**Re: SSD 7714 Blacktown Hospital Stage 2 Main Works at Marcel Crescent,  
Blacktown**

## ATTACHMENT A

2 NORTH ELEVATION
074 1: 200

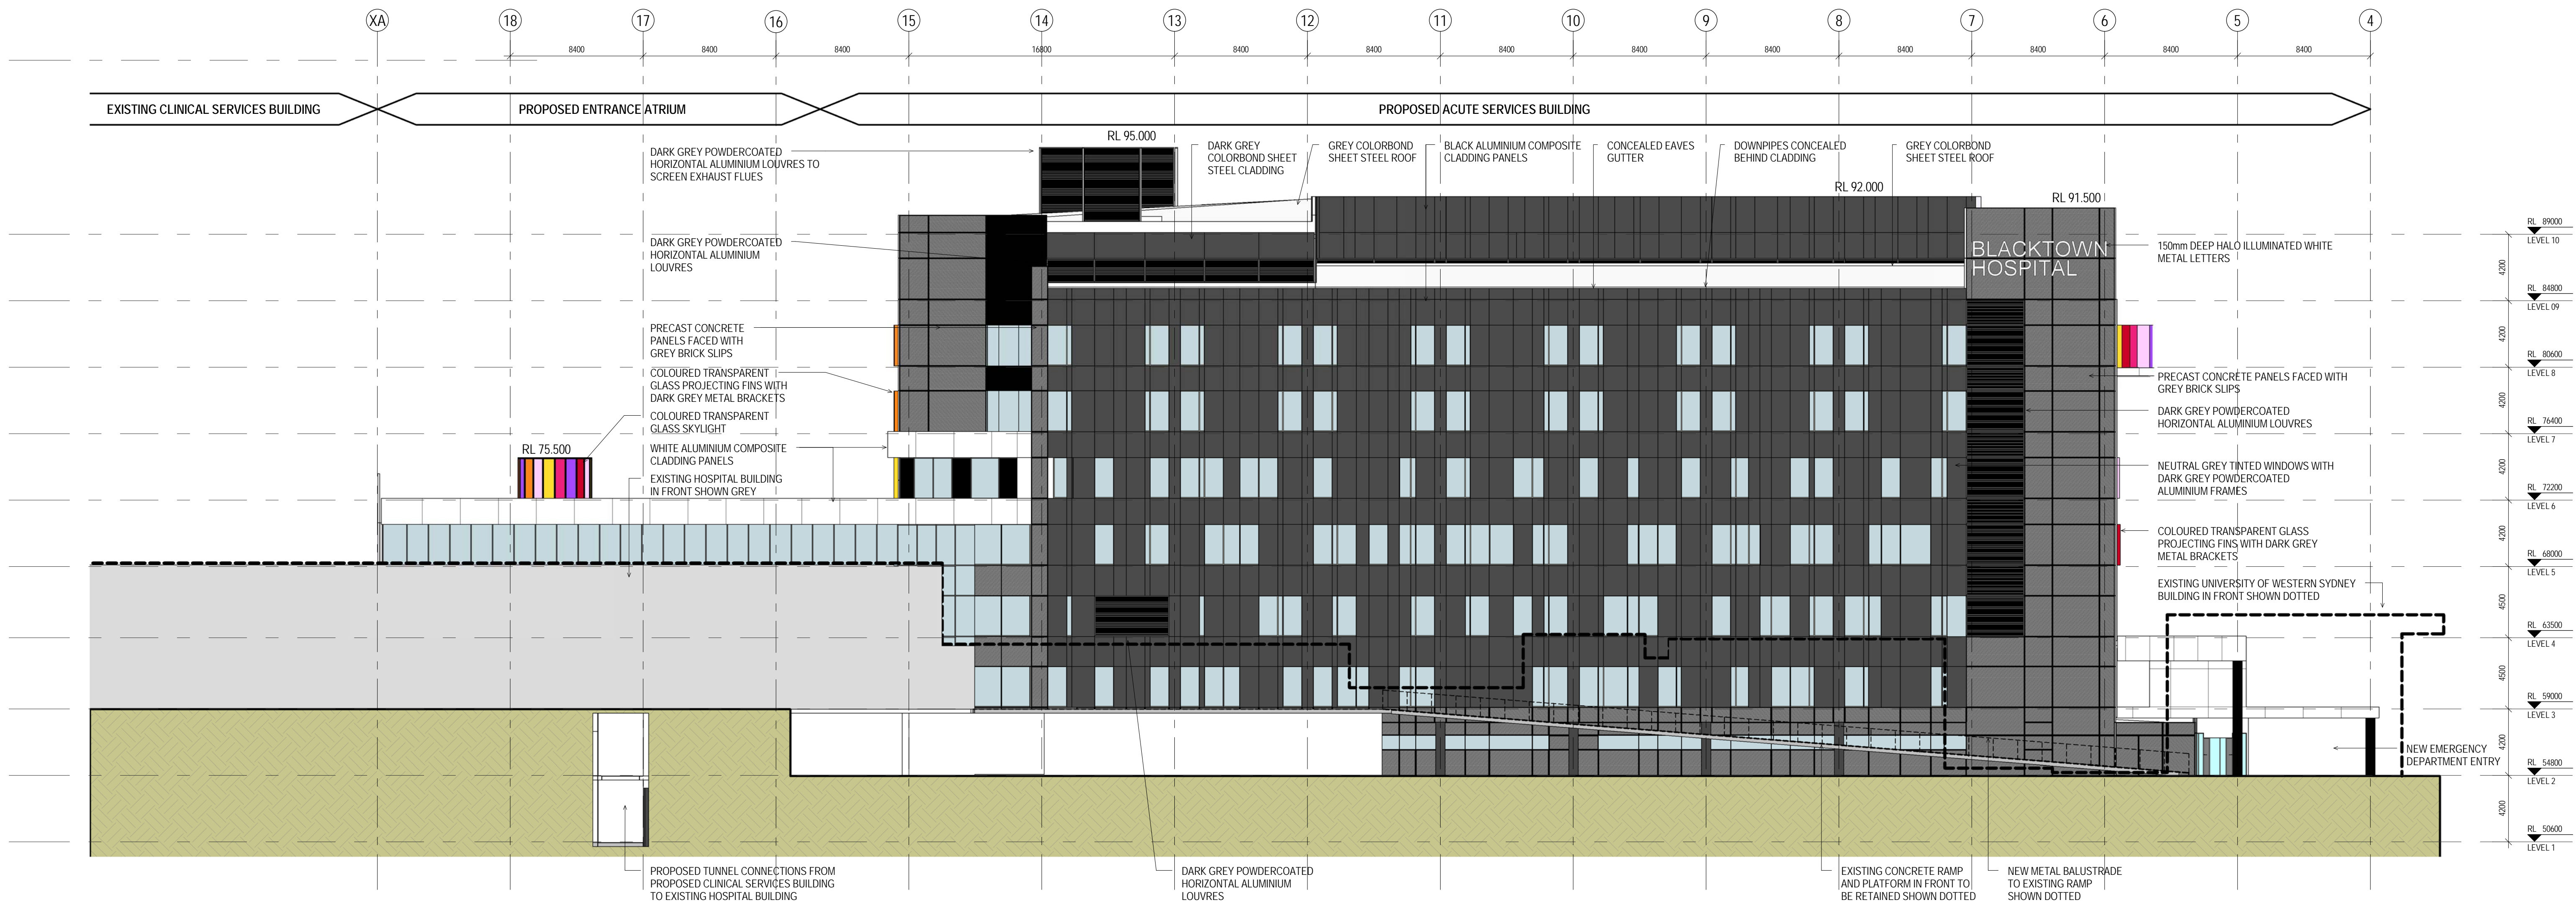
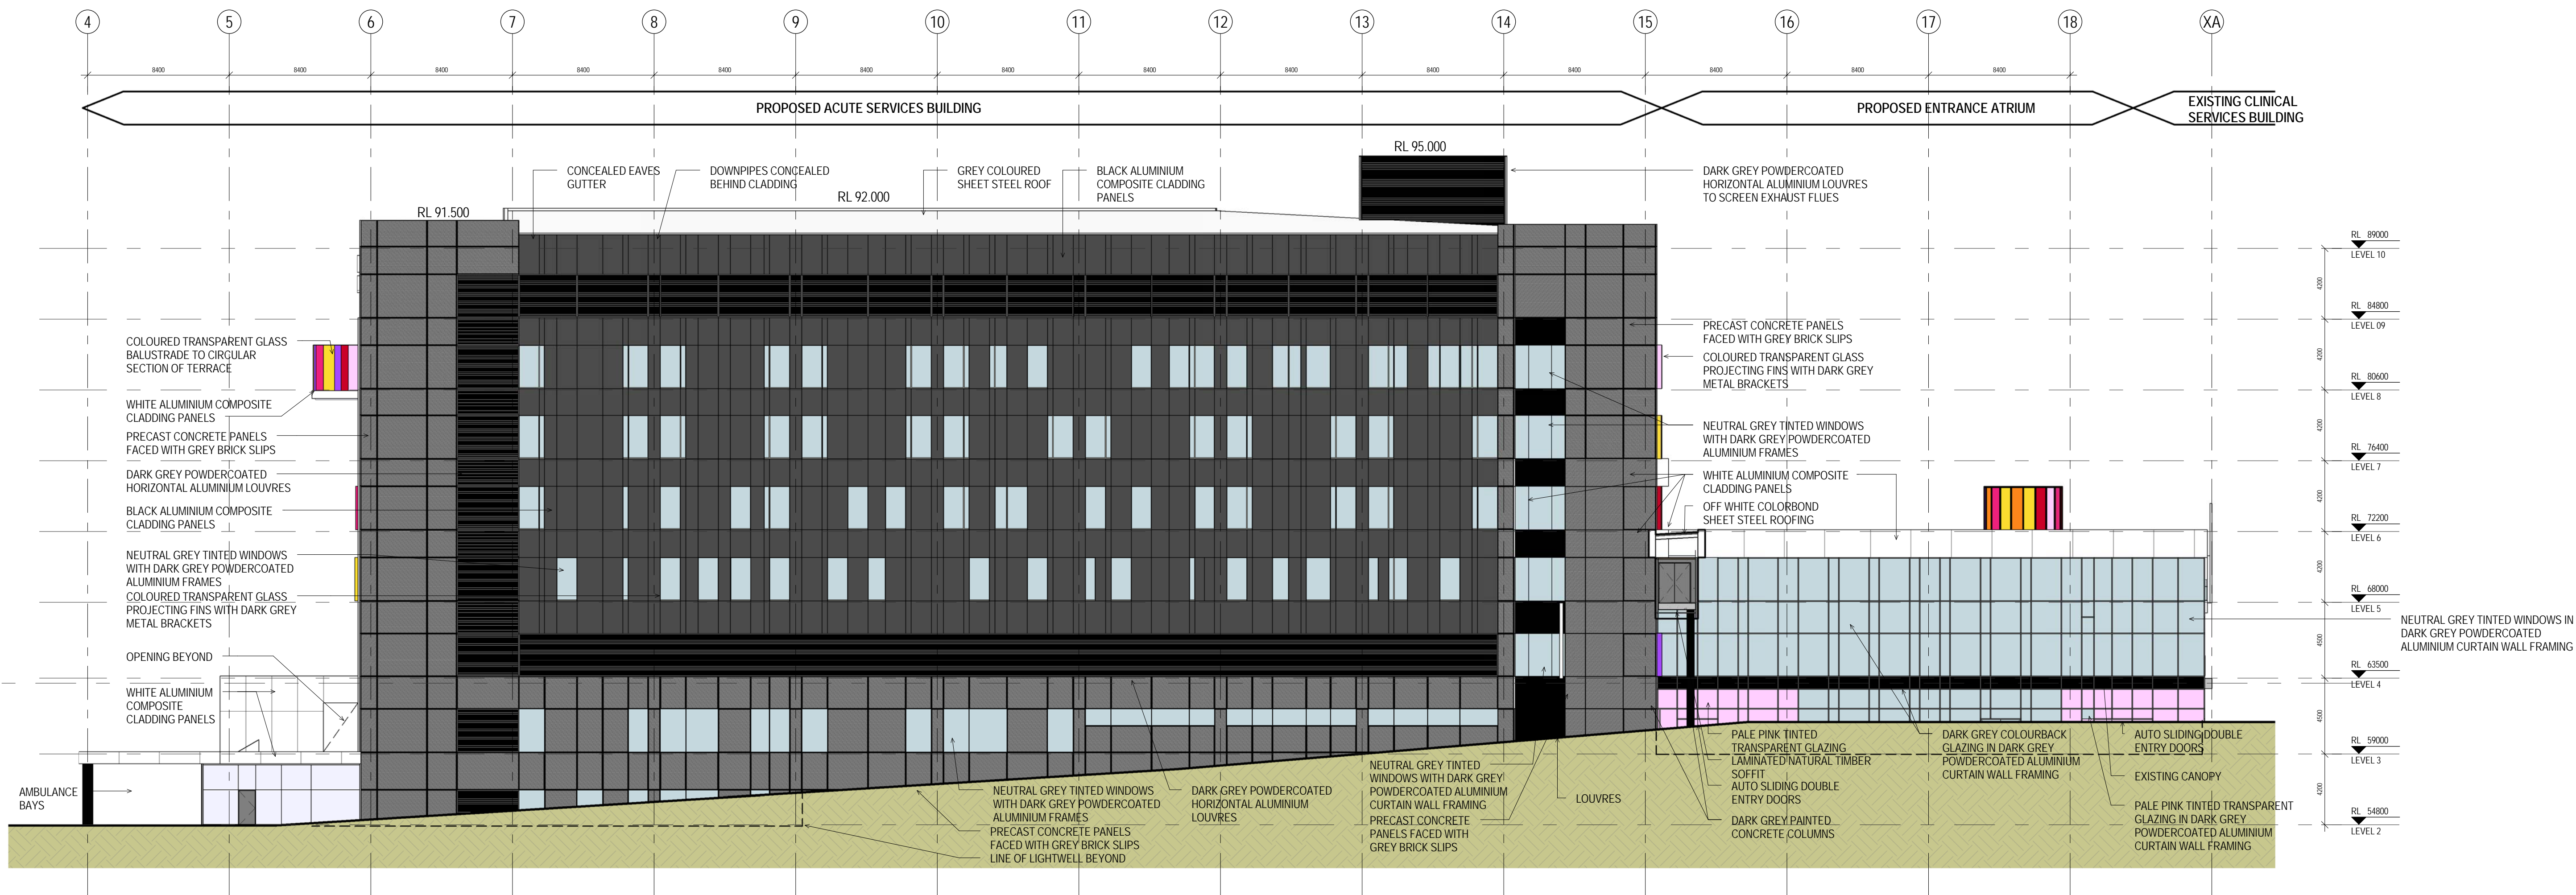
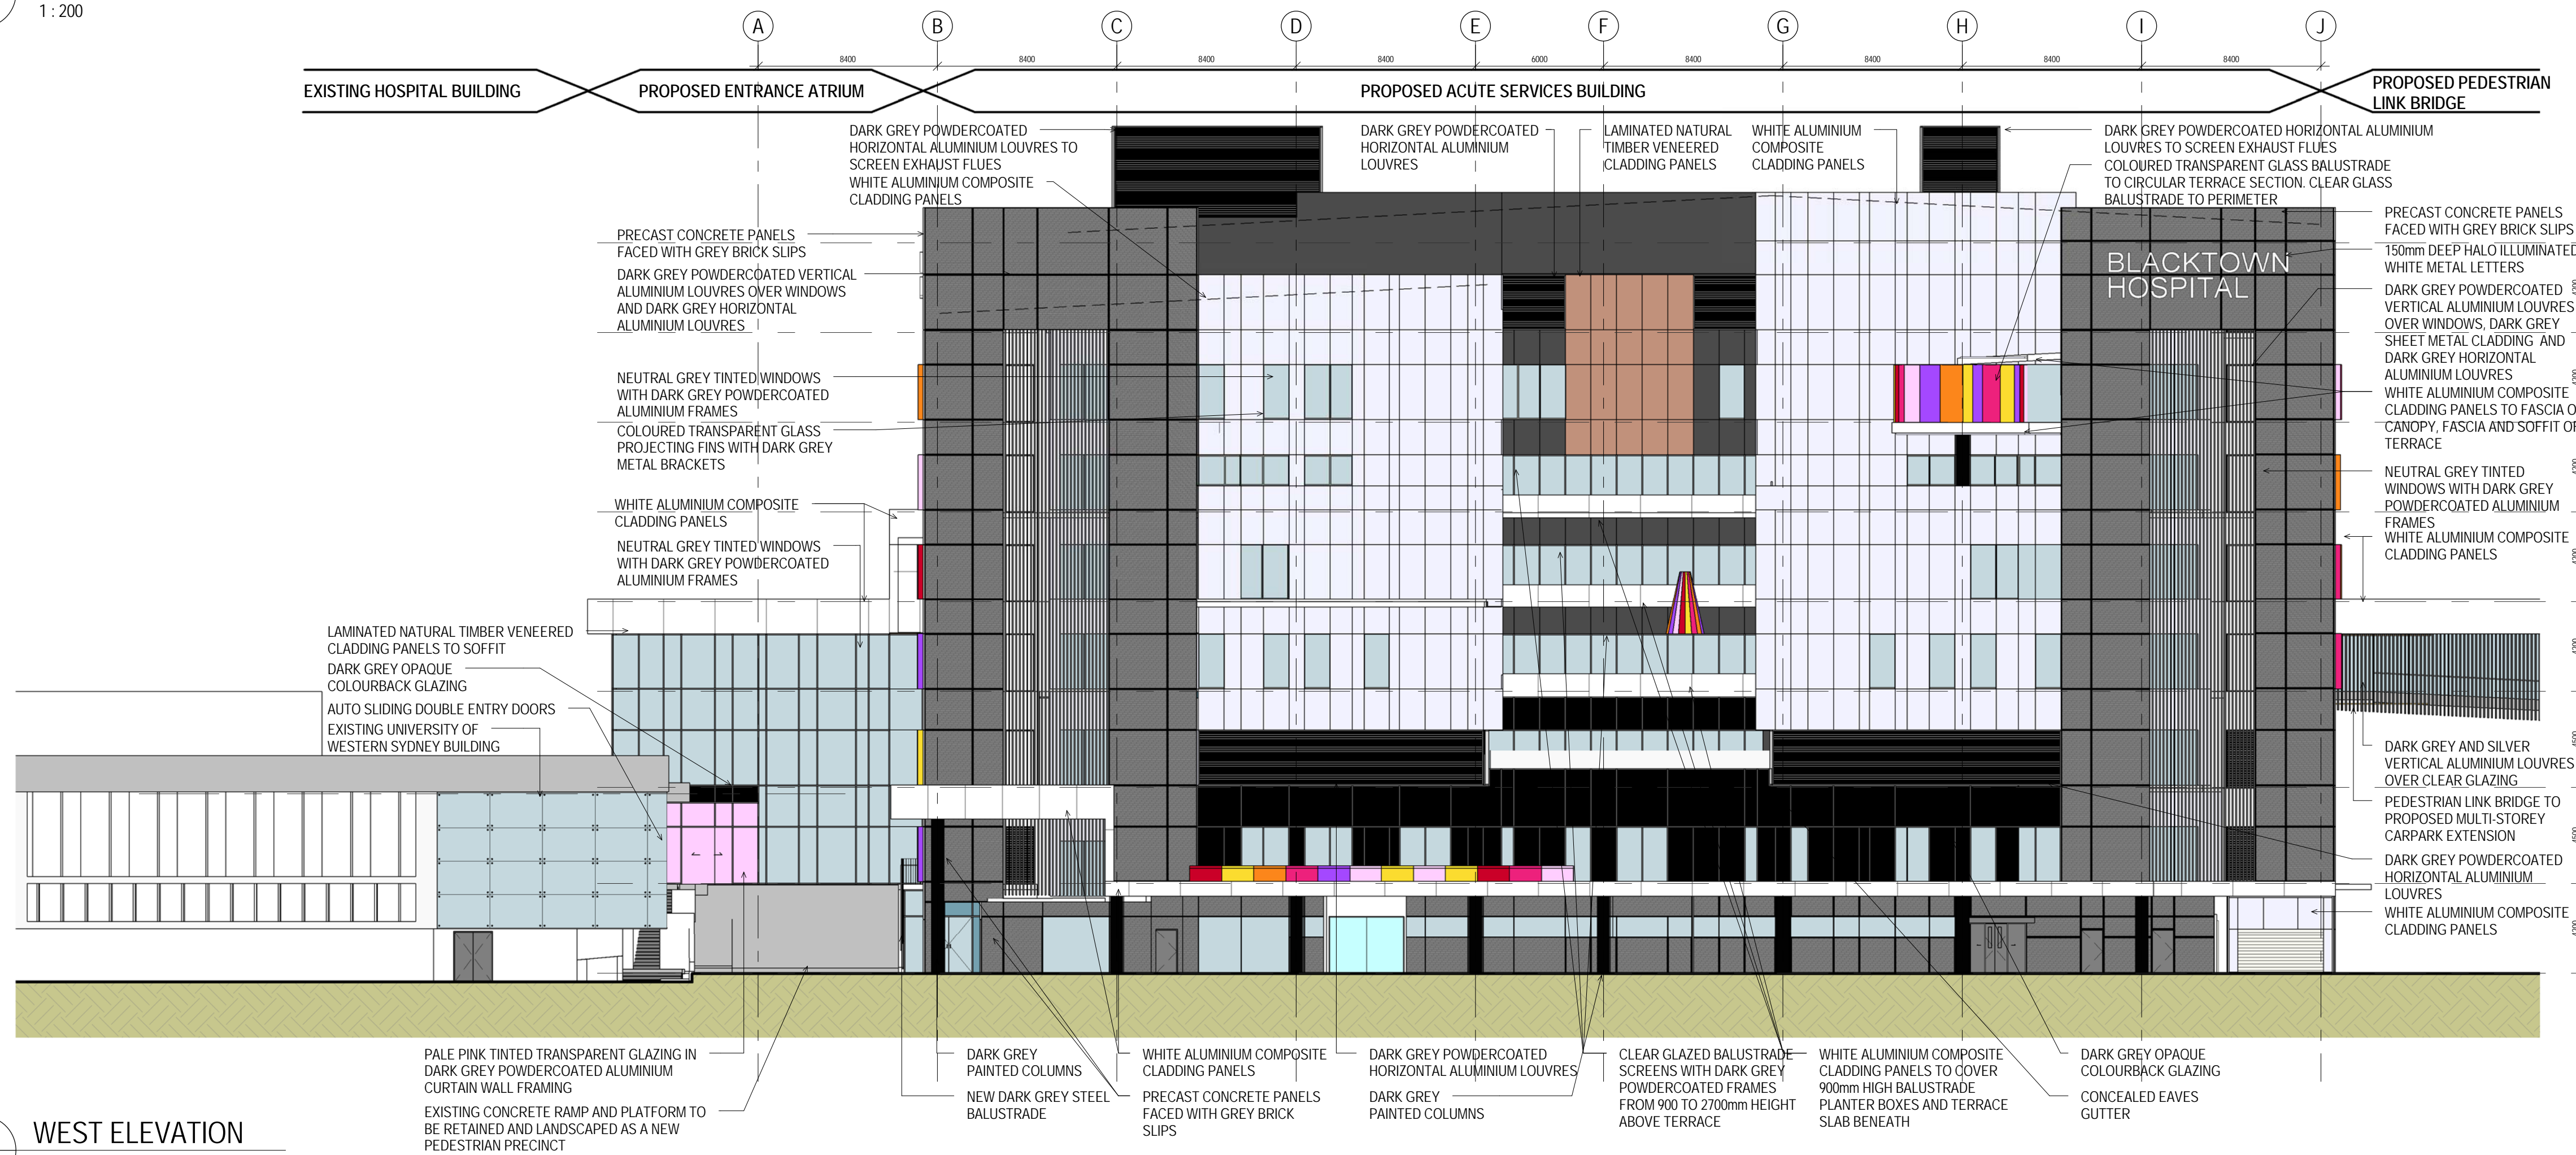
5. The Mitigation Measures detailed at Section 7 of the Environmental Impact Statement are also to include the operational aspects of the proposal for ongoing maintenance and measures to manage and reduce any adverse impacts of the proposal overtime. For example managing the operational impacts outlined at Section 5.4.2.
6. The Concept Approval SSD 7058 approved a building envelope for a 9 storey building with a maximum RL of 89.3 (including rooftop plant and equipment). This proposal increases the overall building height to RL 92.0 to the roofline of the plant level and RL 95.0 to further exhaust flues. This is an overall increase of 5.7 m.

Concern is raised that the top most level of the building (Level 9) and the rooftop screening of the exhaust flues (Level 10), which are dark in colour, are prominent features which exaggerate the substantial height of the building. We believe it would be appropriate to alleviate the impact of this increased height by having the upmost portions of the building being lighter in colour to blend in with the skyline, for example lighter grey or sky blue in colour.
